Arun District Council
Arun Civic Centre
Maltravers Road
Littlehampton
West Sussex BN17 5LF
Planning & Building Control General Enquiries
Tel: (01903) 737756 Fax: (01903) 730442
Dx: 57406 Littlehampton
Minicom: 01903 732765
e-mail: planning@arun.gov.uk
website: www.arun.gov.uk/planning

1st June 2020

Application No: BR/99/20/PL
Site Address: 23 Mead Lane Bognor Regis PO22 8AP
Description of works: Change of use from Student Accommodation to 3 No. dwellings, comprising 1 No. 1 bed apartment, 1 No. 2 bedroom house & 1 No. 3 bedroom house. This application affects the character & appearance of the Upper Bognor Road & Mead Lane Conservation Area & may affect the setting of a Listed Building.

SOUTHERN ELEVATION

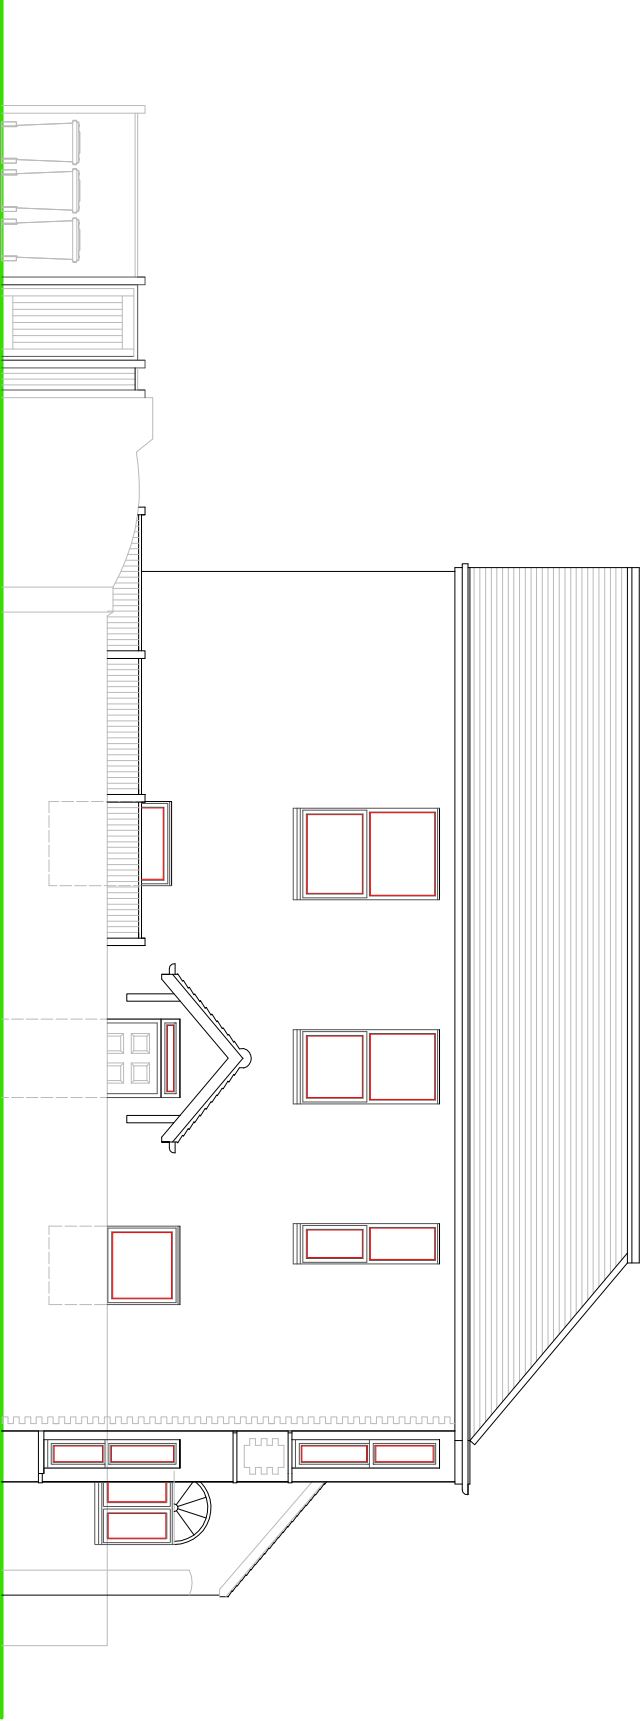
(2) the front doorway (existing?) to Unit 3 seems to be shown as a new window instead of a door on the proposed south elevation.

EASTERN ELEVATION

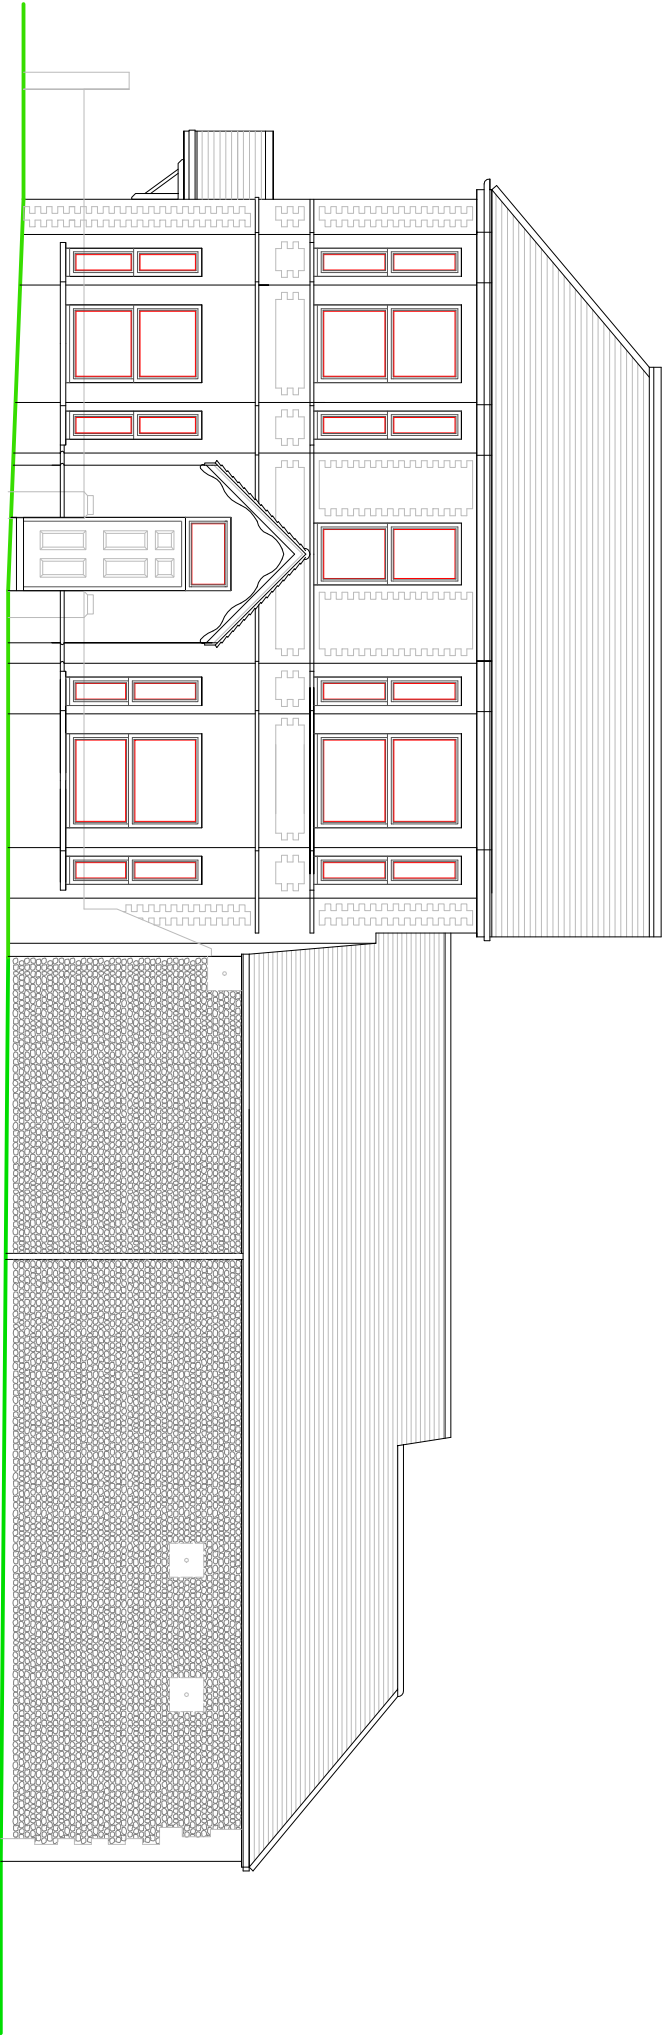
(1) the use of conservation style rooflights, and the proposal not to alter the east (street) elevation of the single storey flint structure is welcomed. However, great care will be needed in the infilling of the large opening in the north elevation of the single storey structure and it is suggested that precise details of the brick to be used, brick bond and mortar/pointing should be the subject of a planning condition. So too should precise details of the two new windows which should each consist of a pair of matching painted timber side hung casements.

(3) although it probably cannot be insisted upon, there is a great opportunity with the new uses to replace all the existing pvcu windows, particularly on the east and south elevations, with painted timber vertically sliding

sash windows which would significantly improve the appearance of the building and enhance the appearance of the conservation area. It will be extremely important, though, to ensure that the existing timber sash windows are retained and repaired where necessary and if beyond repair are replaced with matching windows of like for like materials and design.
